CITY OF ALBUQUERQUE

August 20, 2012

**Re: Boulders Phase II and III
Grading and Drainage Plan
Engineer's Stamp Date 7/26/2012 (B11/D001C)**

|  |                 | TERRA WEST, LLC<br>5571 MIDWAY PARK PLACE NE<br>ALBUQUERQUE, NM 87109<br>(505) 858-3100<br>terrawestllc.com |  | DRAWING<br>OVERALL GRADING |

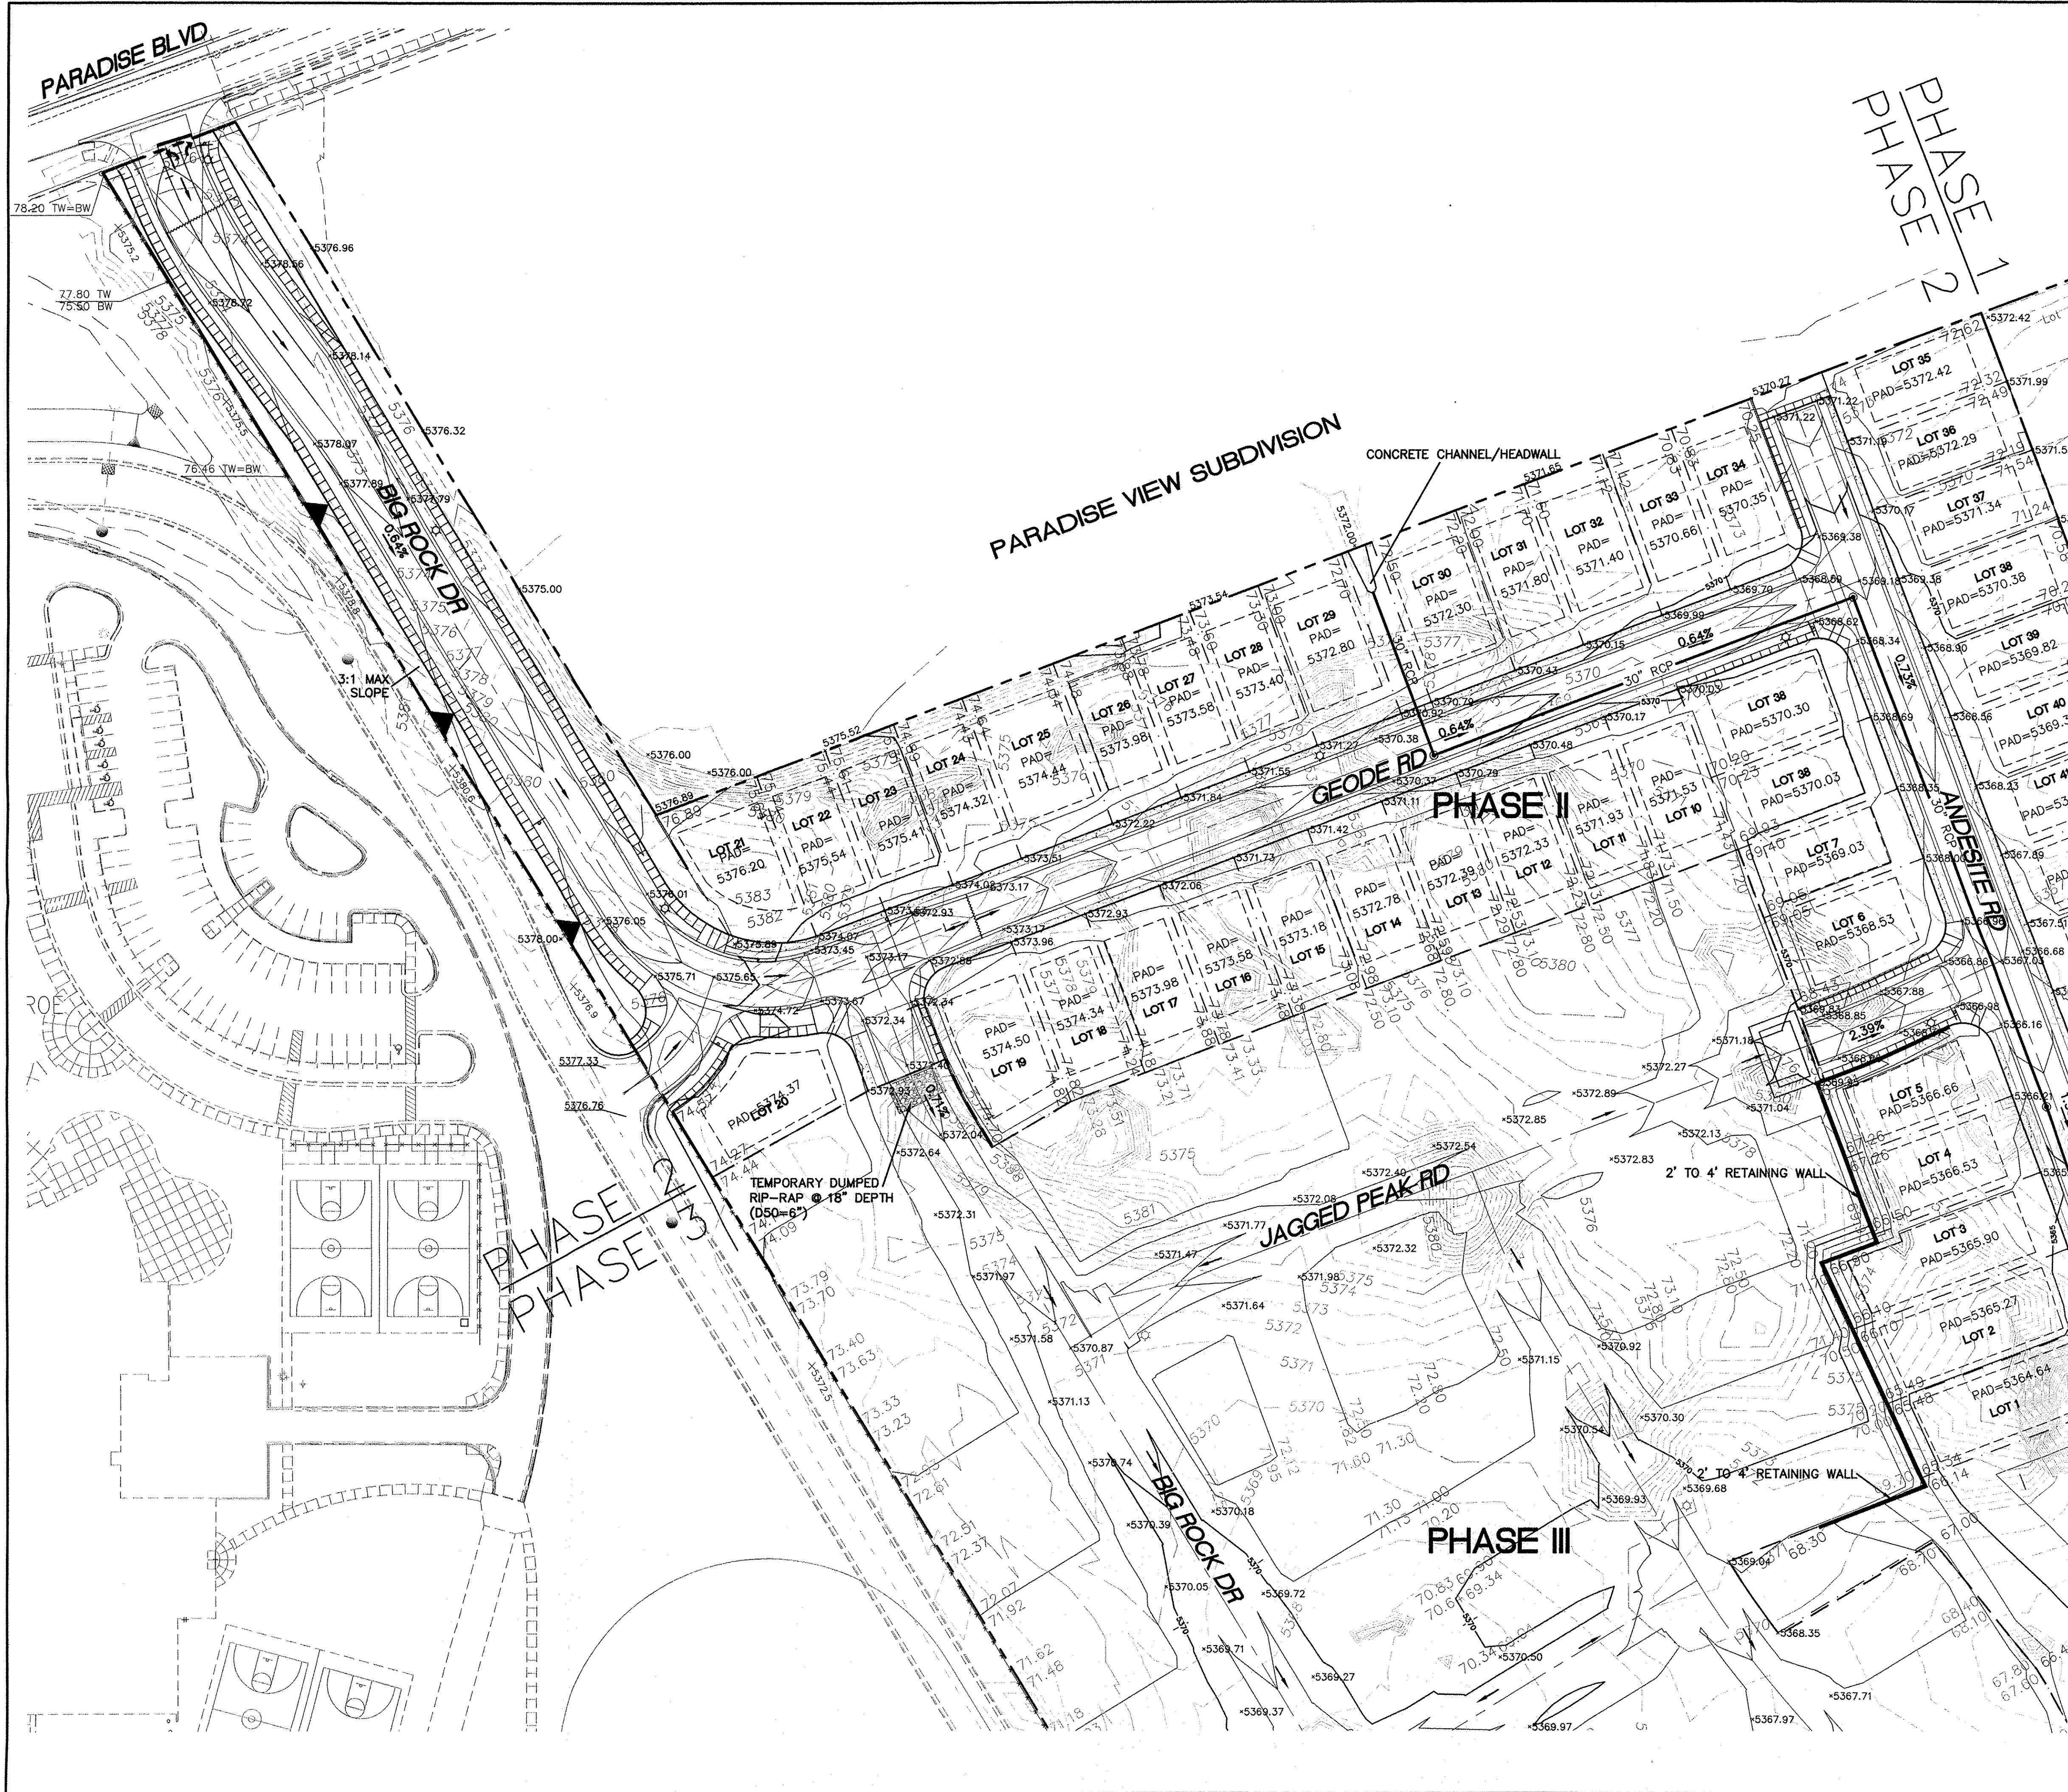
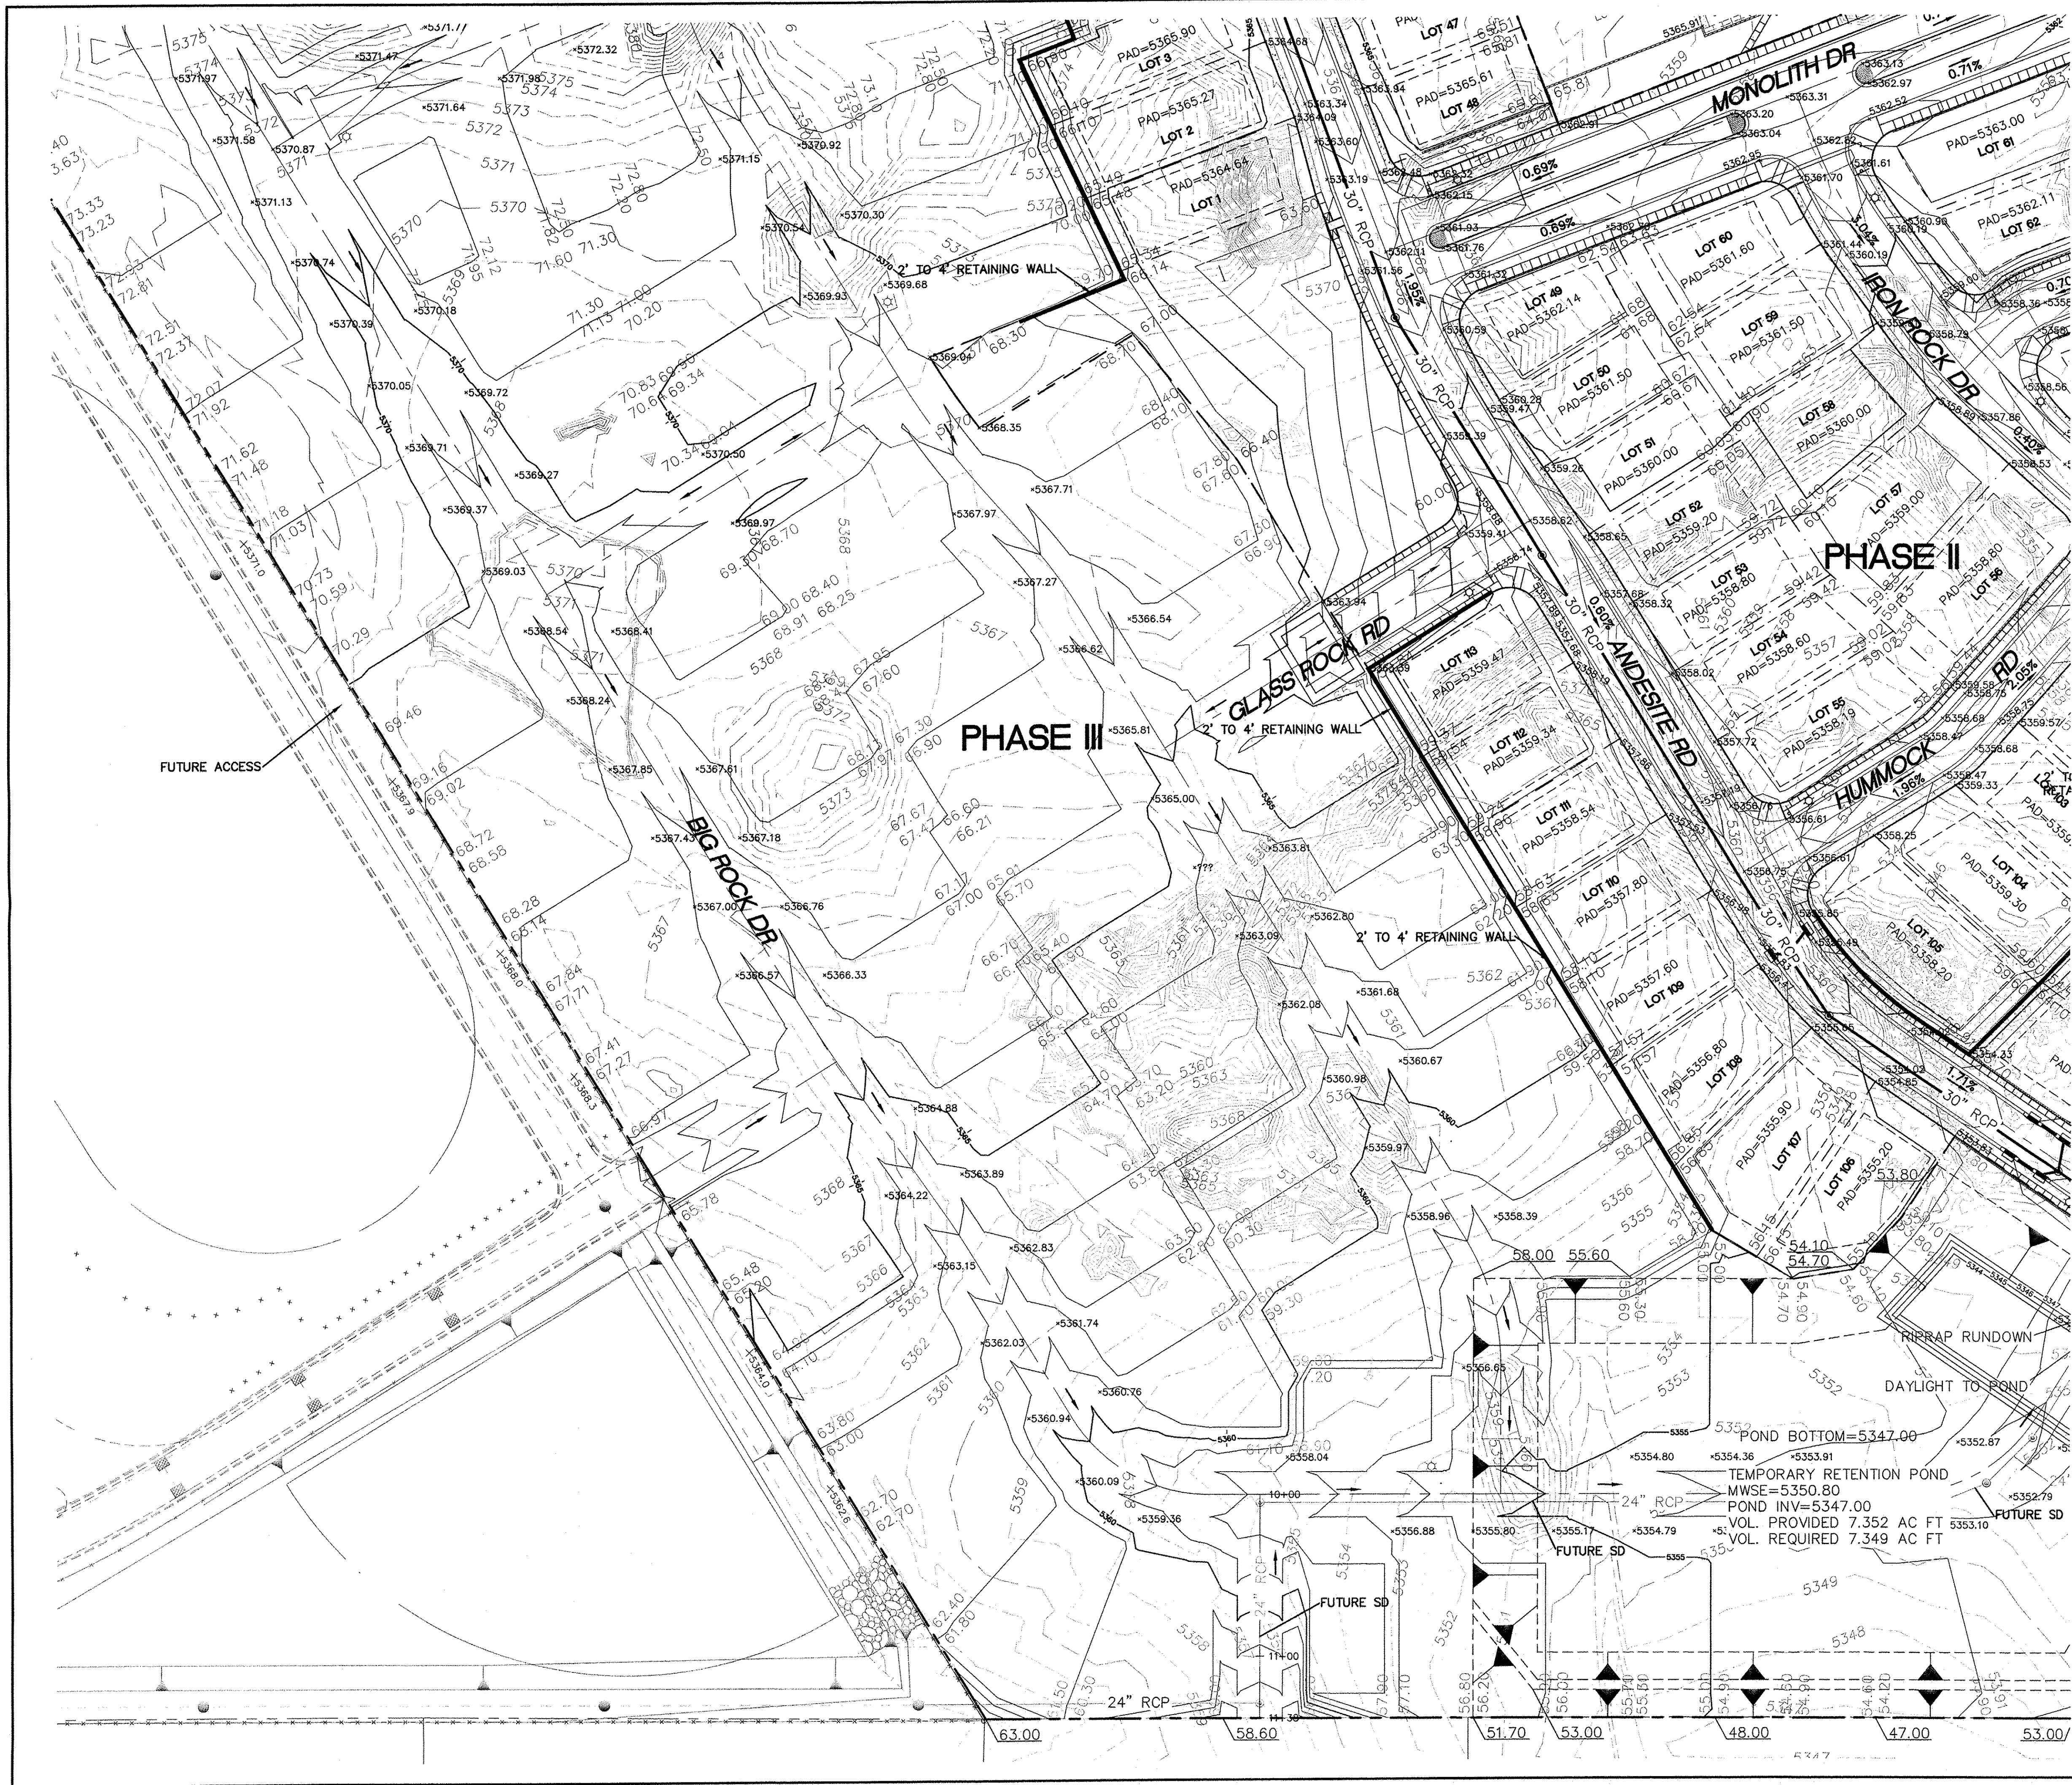
- Please plot the plans on a larger scale (1"=50').
- Add existing elevations along the property lines.
- Provide grades and slopes along the centerline of the streets.
- Street capacity analysis was not provided for Phases II and III.
- Include storm drainage calculations for the proposed inlets, storm drain pipes, and other drainage structures.
- Add lot numbers.
- Provide sections for the retention pond.
- More detail is required for the portion of the storm drain being proposed through the retention pond. What portions of the storm drain will be built? Provide a copy of the proposed plat and infrastructure list.
- Maintenance and Covenant will be required for the proposed retention pond.
- Have the grades been certified for the retention pond east of Unser Blvd.?
- Additional comments may be provided when the revised plan is submitted.
